From: Joanne Lewis <Joanne.Lewis@arun.gov.uk>
Sent: 07 June 2022 15:01
To: Planning.Responses <Planning.Responses@arun.gov.uk>
Subject: RE: Planning Consultation on: LY/5/22/PL

Application No: LY/5/22/PL

Site Address: Crossbush Service Station Lyminster Road Lyminster BN17 7QQ

Description of Works: Installation of 8 No. electric vehicle charging bays and associated infrastructure. This application is in CIL Zone 3 (zero rated) as other development.

Rev	Date	Comments
STATUS		PLANNING
PROPOSAL		ELECTRIC VEHICLE CHARGE POINTS
SITE LOCATION		CROSSBUSH SERVICE STATION LYMINSTER ROAD LITTLEHAMPTON, BN17 7QQ
TITLE		PROPOSED ELEVATIONS
CLIENT		Rontec Service Stations 1A Ltd

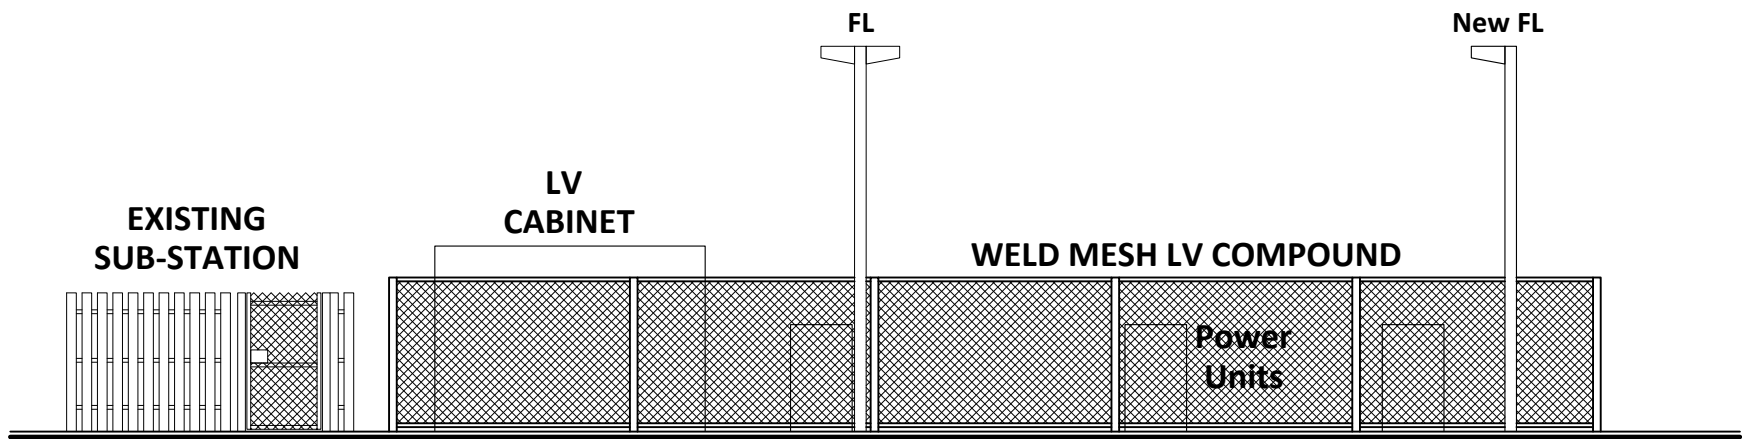
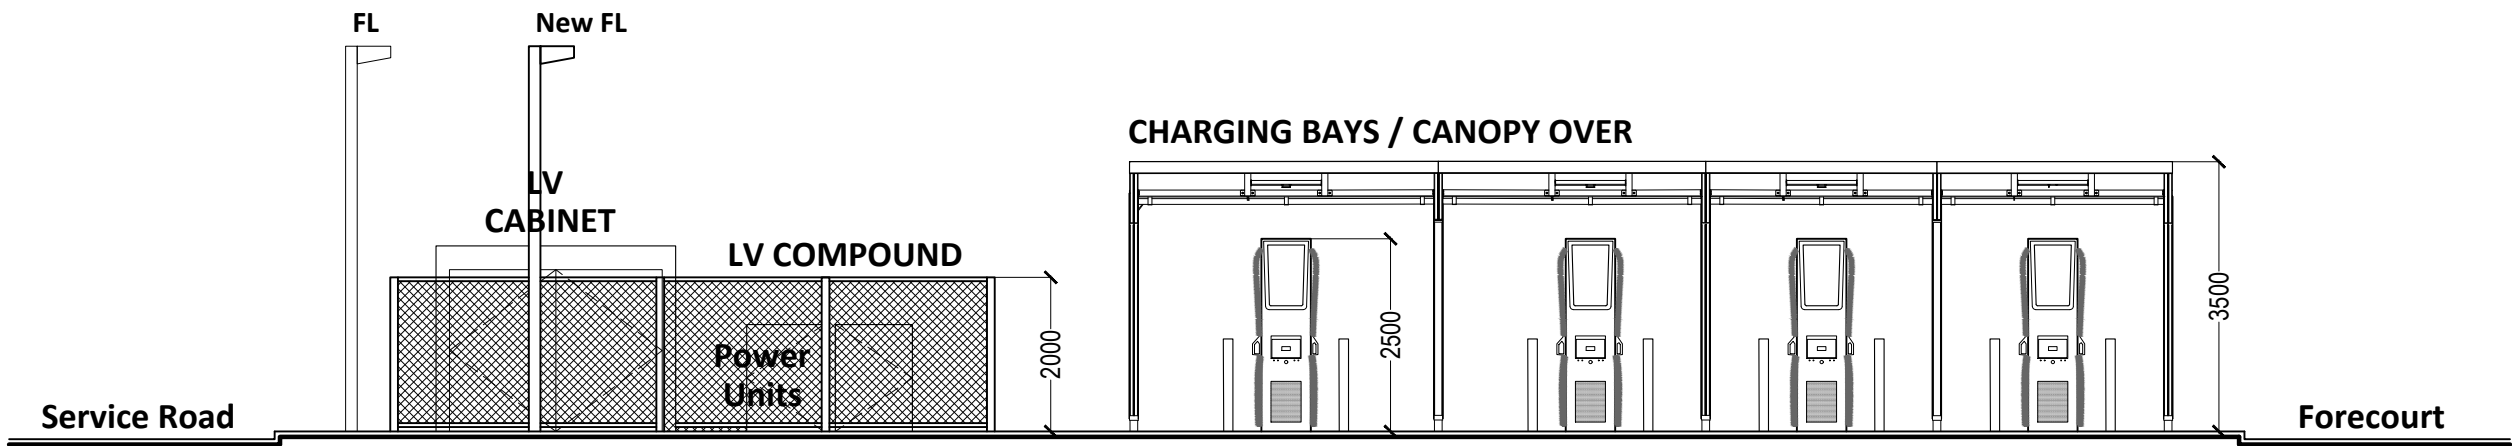
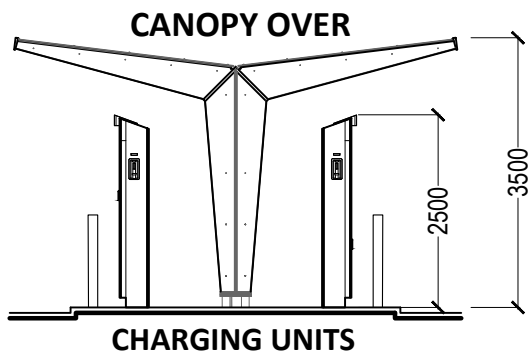
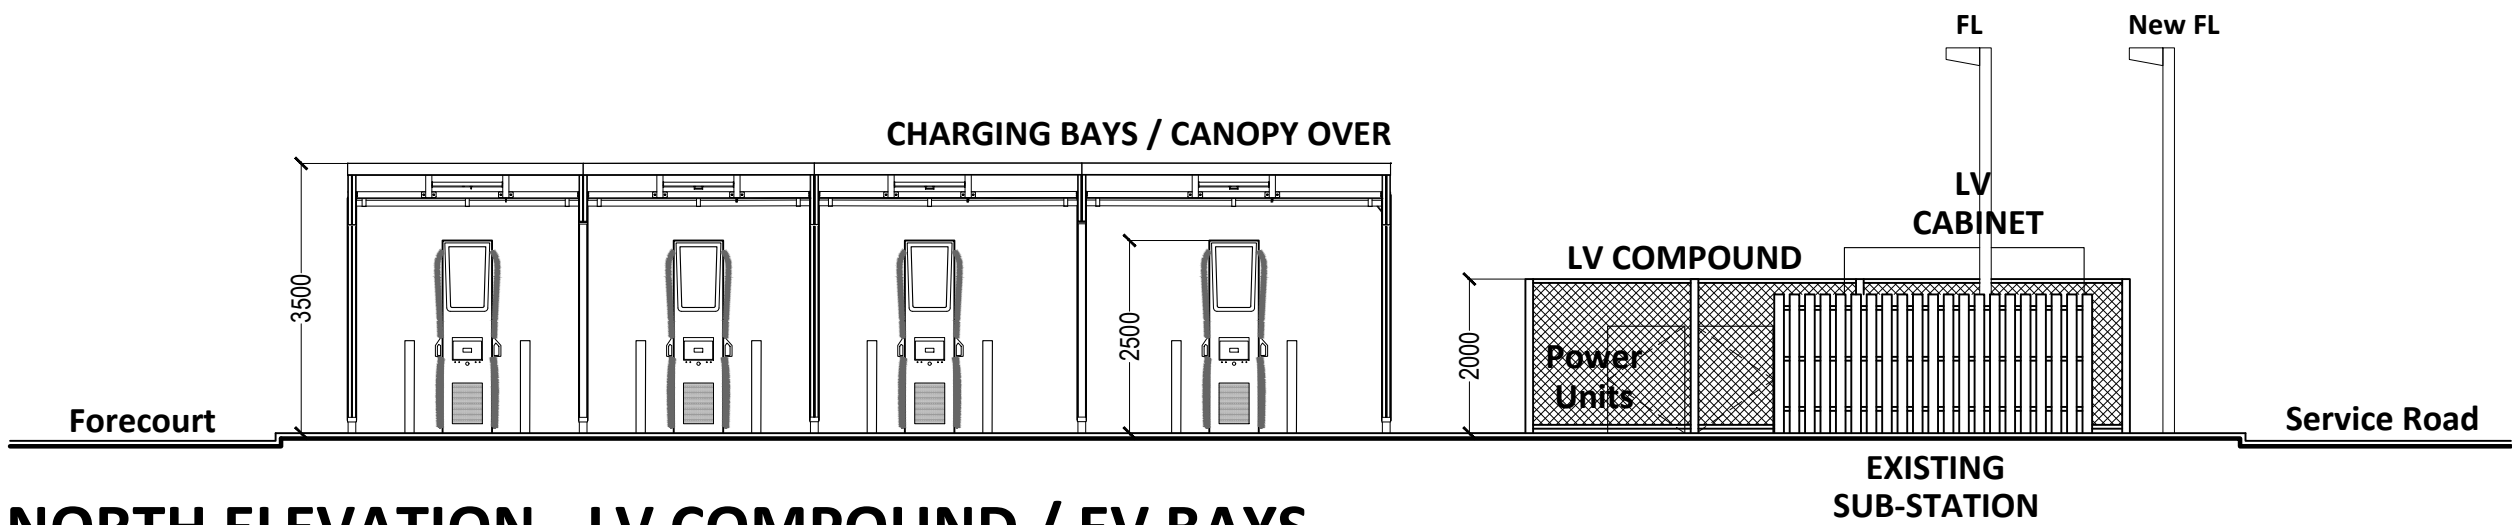
No technical details of the charge points or LV compound have been provided. In order to ensure that the charge points and LV compound equipment are suitable for the location please could the applicant provide manufacturer/technical specifications for the equipment to be installed.
